Planning and Development Services
Arun Civic Centre
Maltravers Road
Littlehampton
West Sussex
BN17 5LF

Proposal: Outline application with some matters reserved for the demolition of derelict 2-storey office building & erection of 8 no. 2-bed flats & 6 no. 1-bed flats with ground floor parking, bin & cycle storage & children play area.

Site: Formerly Westside Supplies 17/18 Durban Road, Bognor Regis, West Sussex PO22 9RY.
BR/341/10/

BLOCK & SITE LAYOUT PLAN

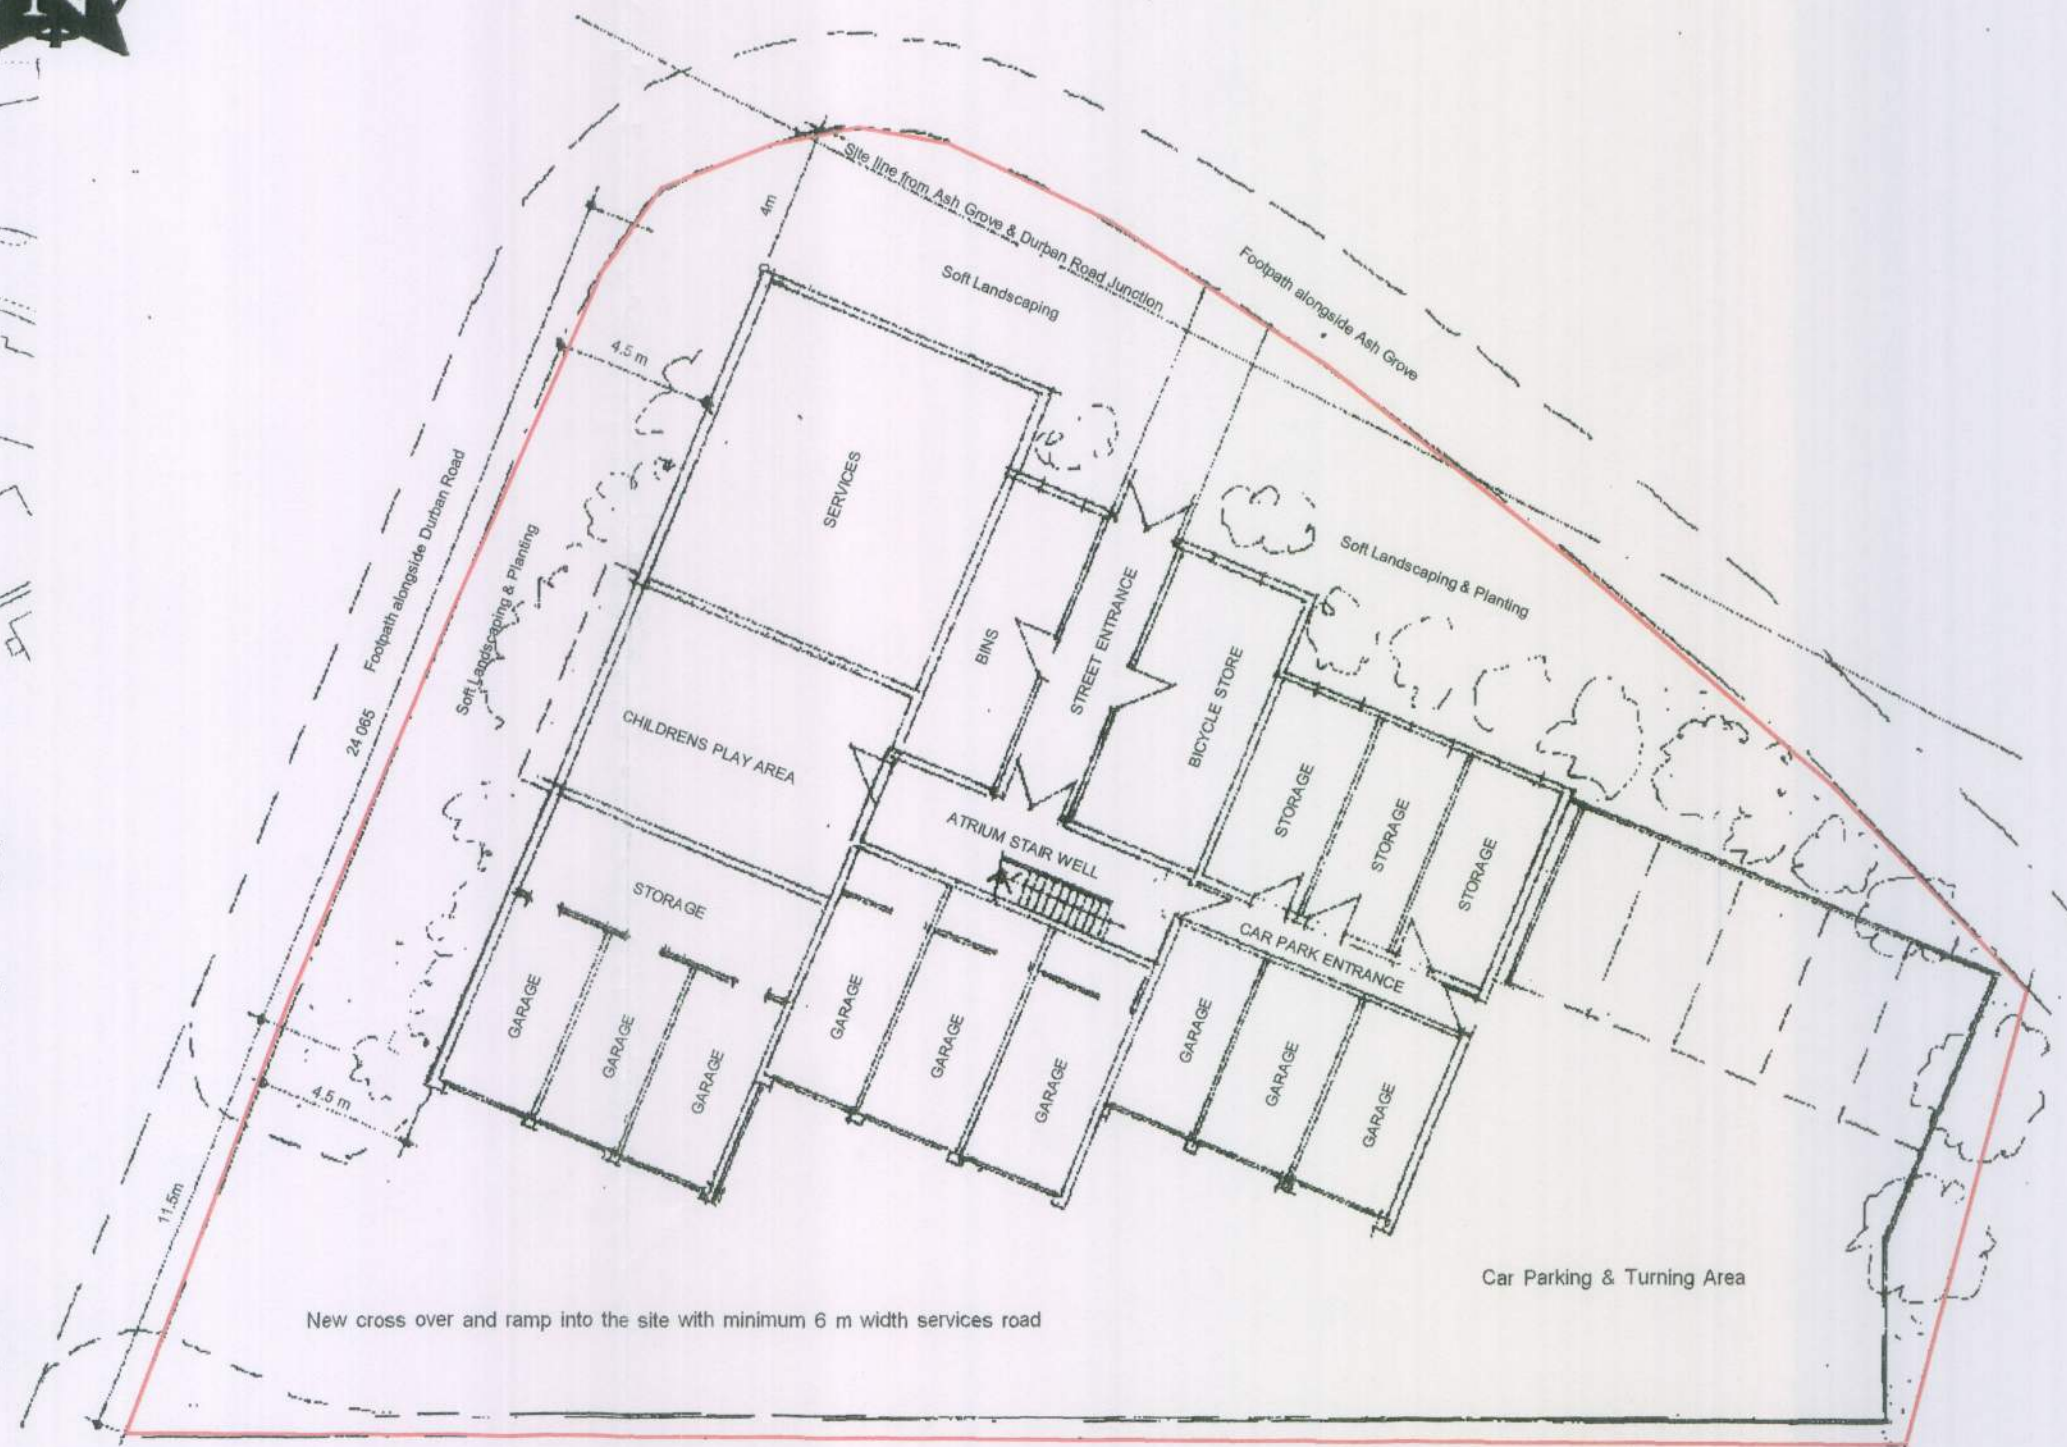
The Flood Risk Assessment details the surface water drains to public surface water sewers. However, the application form and Flood Risk Assessment are not consistent. Southern Water requires a formal application for a connection to the public sewer to be made by the applicant or developer.

We request that should this application receive planning approval, the following condition is attached to the consent: "Construction of the development shall not commence until details of the proposed means of foul and surface water sewerage disposal have been submitted to, and approved in writing by, the Local Planning Authority in consultation with Southern Water."
